EXHIBITION OF ENVIRONMENTAL IMPACT STATEMENT (SSD_5353)
CALTEX KURNELL PORT AND BERTHING FACILITY PROJECT, BOTANY BAY

ATTACHMENT A

ENVIRONMENT PROTECTION AUTHORITY COMMENTS ON EXHIBITED ENVIRONMENTAL IMPACT STATEMENT

Figure 1-1: Project Site and Context (source: URS 2013)

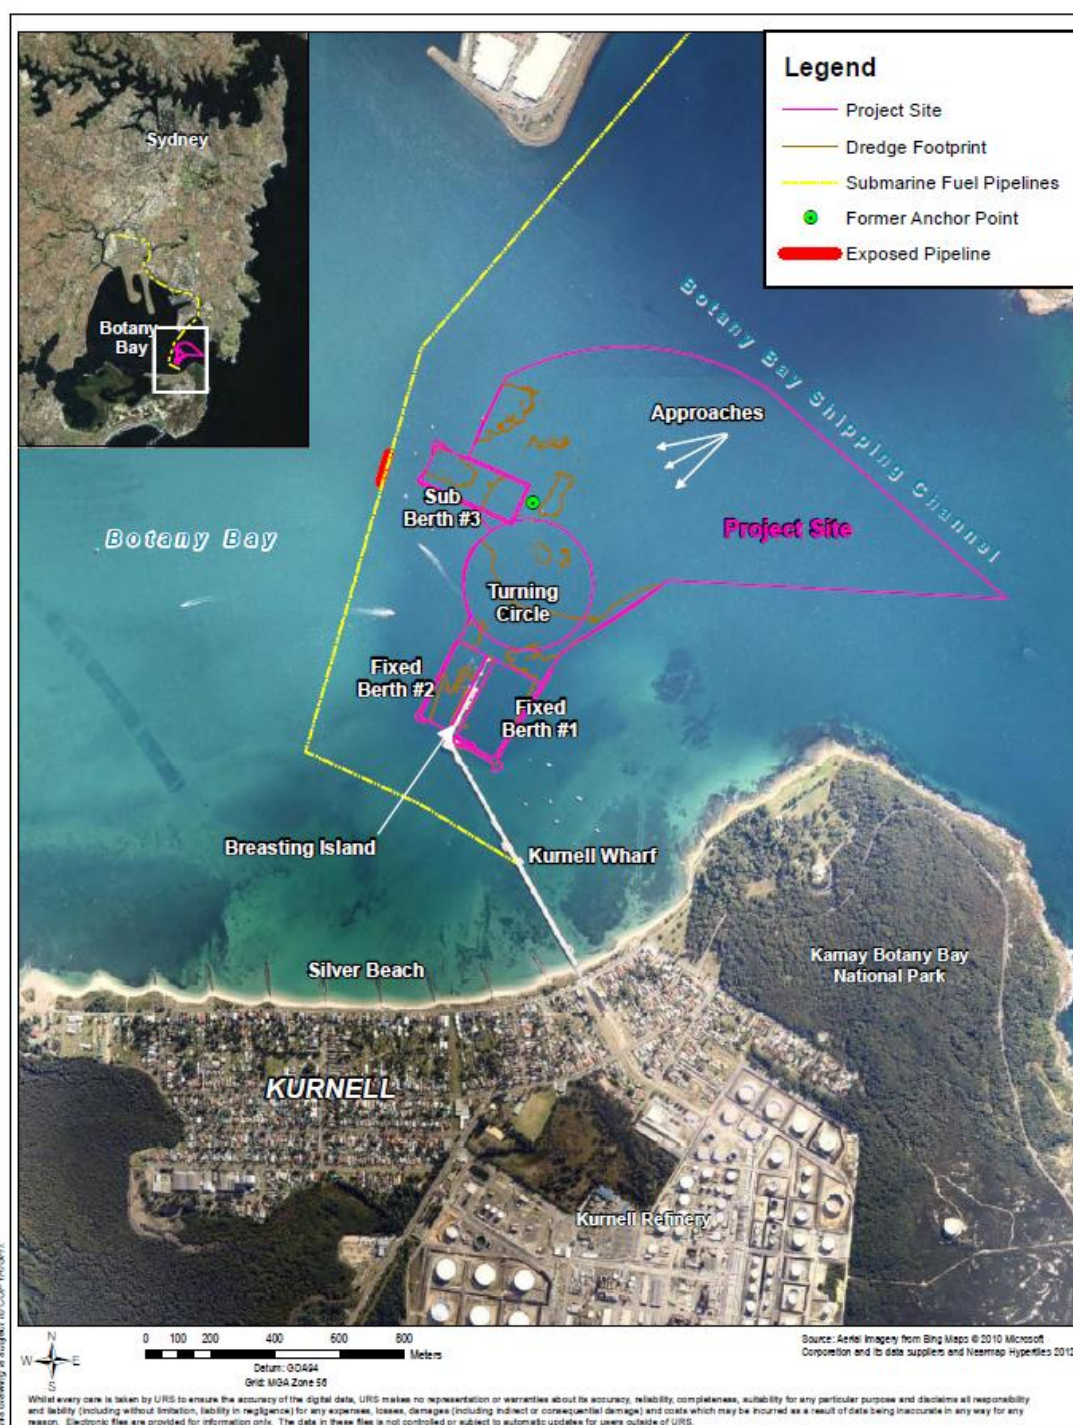
- Figure 4-6 shows the location of the Former Anchor Hole which will be filled with clean material during the dredging operations. Figure 1-1 shows a Former Anchor Point which is in a different location to Figure 4-6. It is unclear from the EIS whether these two points are the same or whether they are two separate reference points. Caltex should clarify this issue as Figure 1-1 has been included in a Caltex Community Information Leaflet in February 2013.
